Application Ref:	3/2026/0702			 Ribble Valley Borough Council www.ribblevalley.gov.uk
Date Inspected:	N/A	Site Notice:	N/A	
Officer:	AR			
DELEGATED ITEM FILE REPORT:				APPROVAL

Development Description:	Non-material amendment to application 3/2026/0426 involving amendments to intercoms and fence posts.
Site Address/Location:	Ribchester St Wilfrids C of E Primary School Ribchester PR3 3XP

South Facing Elevation
(Proposed)

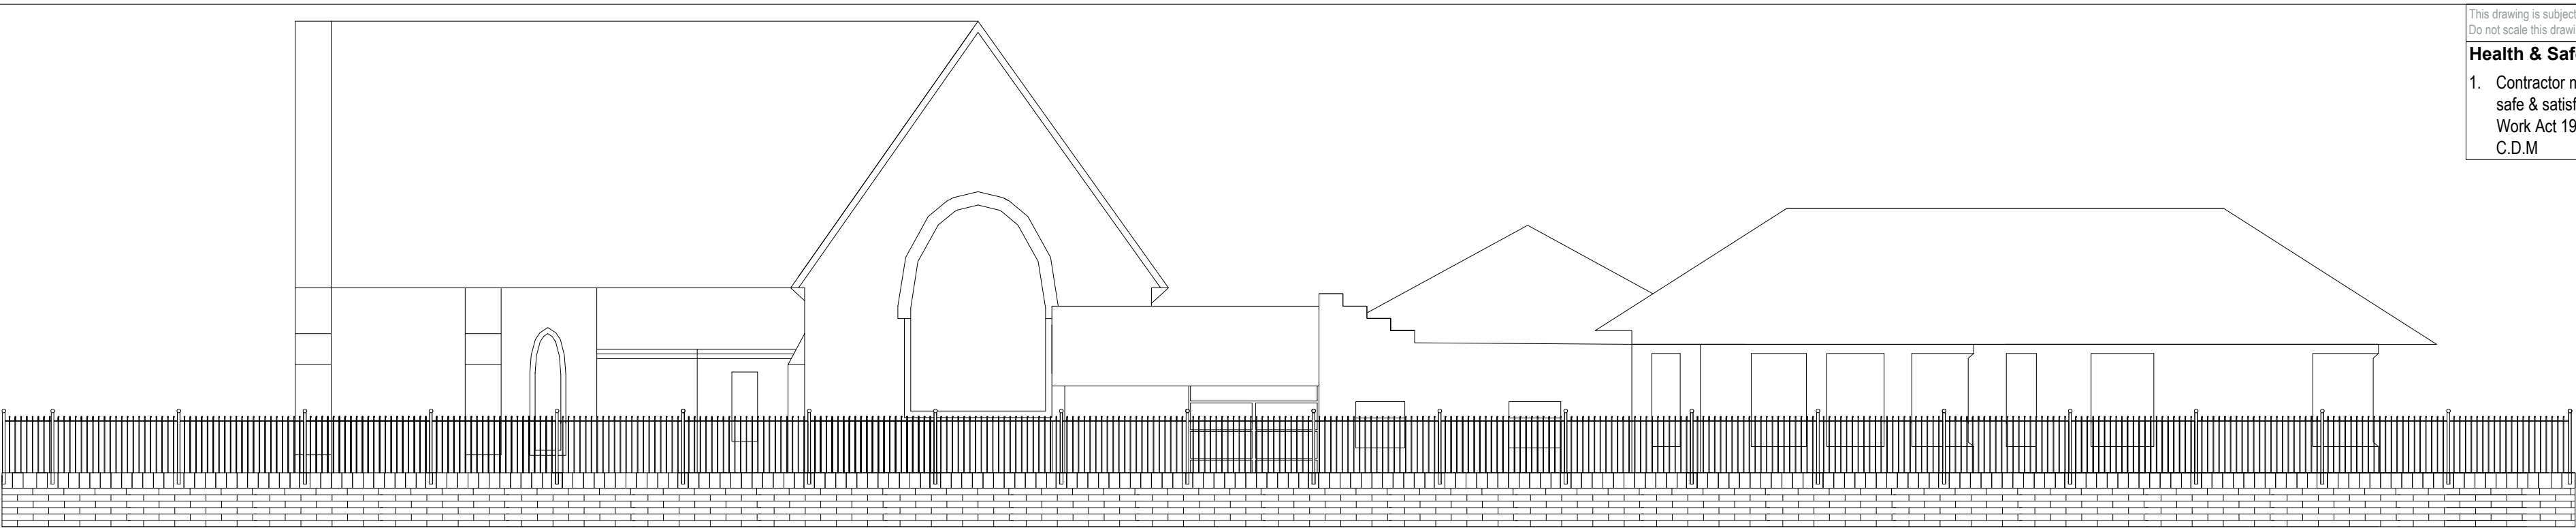
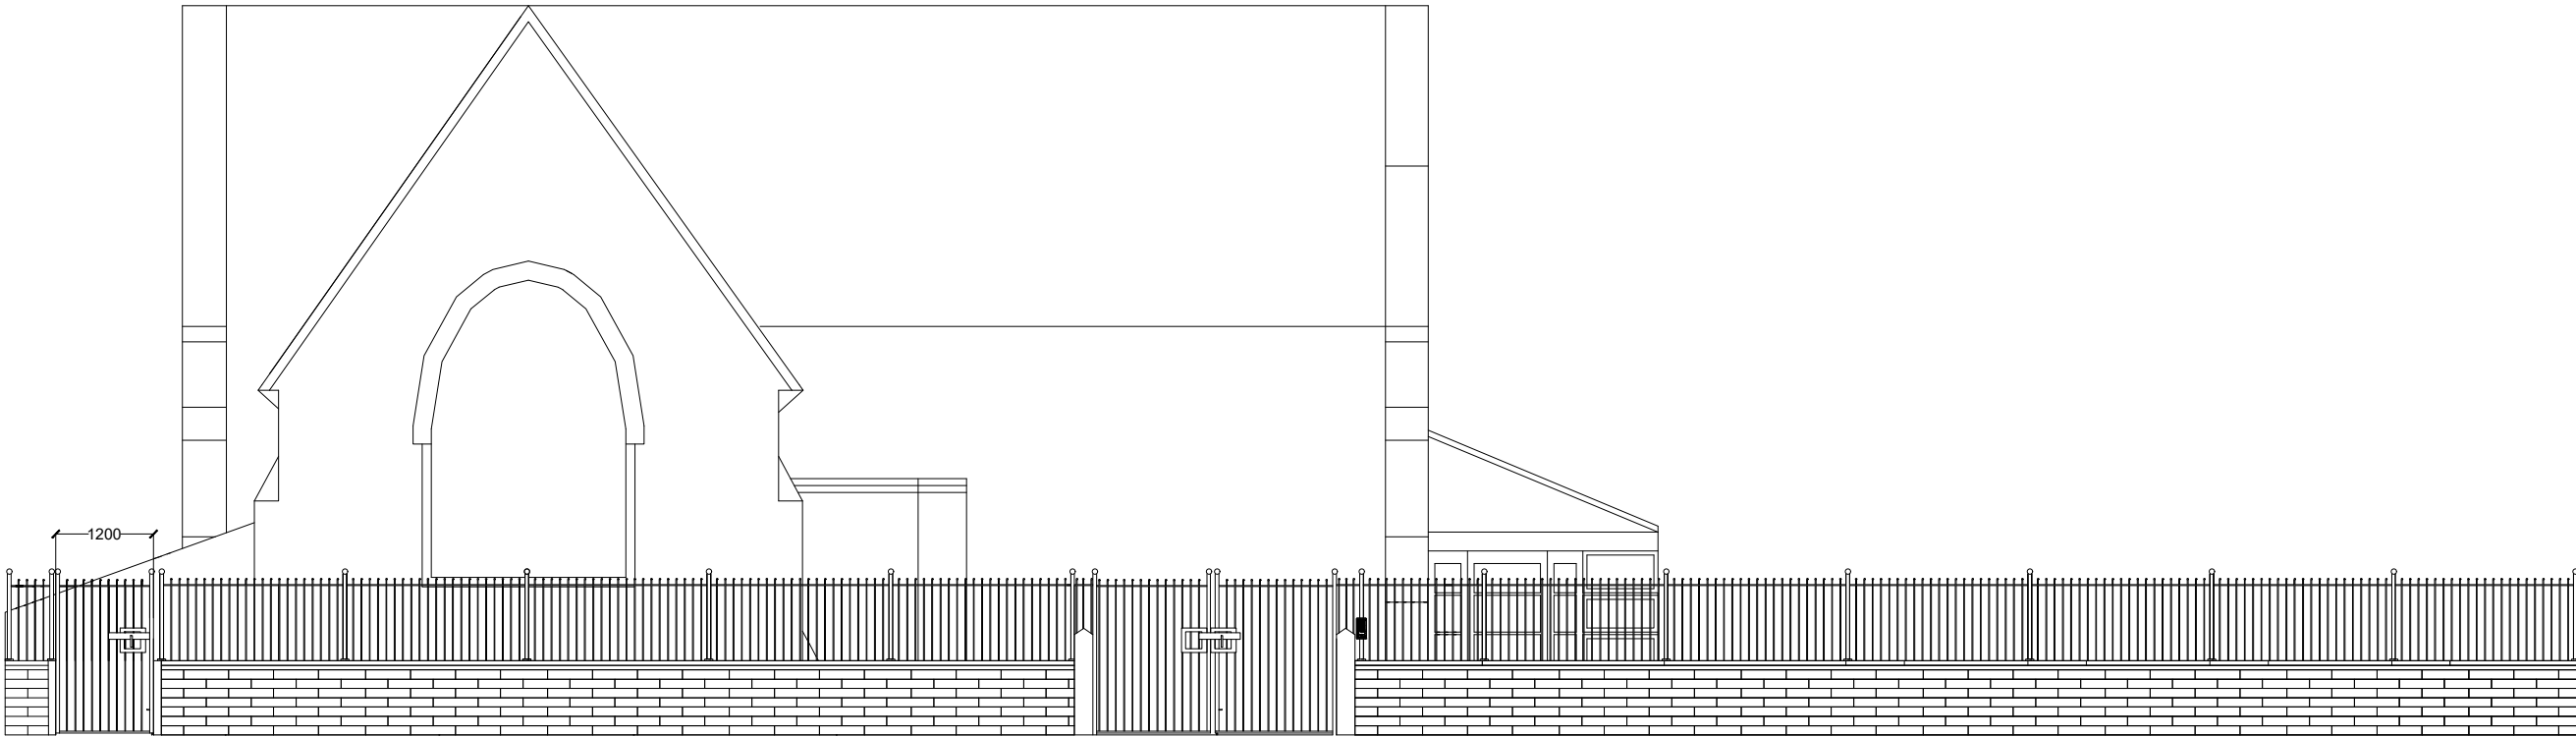
In this instance, the amendment sought relates to the proposed modification of the fence post fixings and the relocation of the audio intercom system. Specifically, No. 1 audio intercom is to be removed from the single-leaf pedestrian gate, and the No. 1 audio intercom currently affixed to the double-leaf pedestrian gate is to be repositioned to the adjacent fence post. Additionally, the fence posts on the western elevation are proposed to be mounted on base plate fixings secured to the masonry wall, while the fence posts along the southern elevation are proposed to be mounted on bracket fixings similarly bolted to the masonry wall.
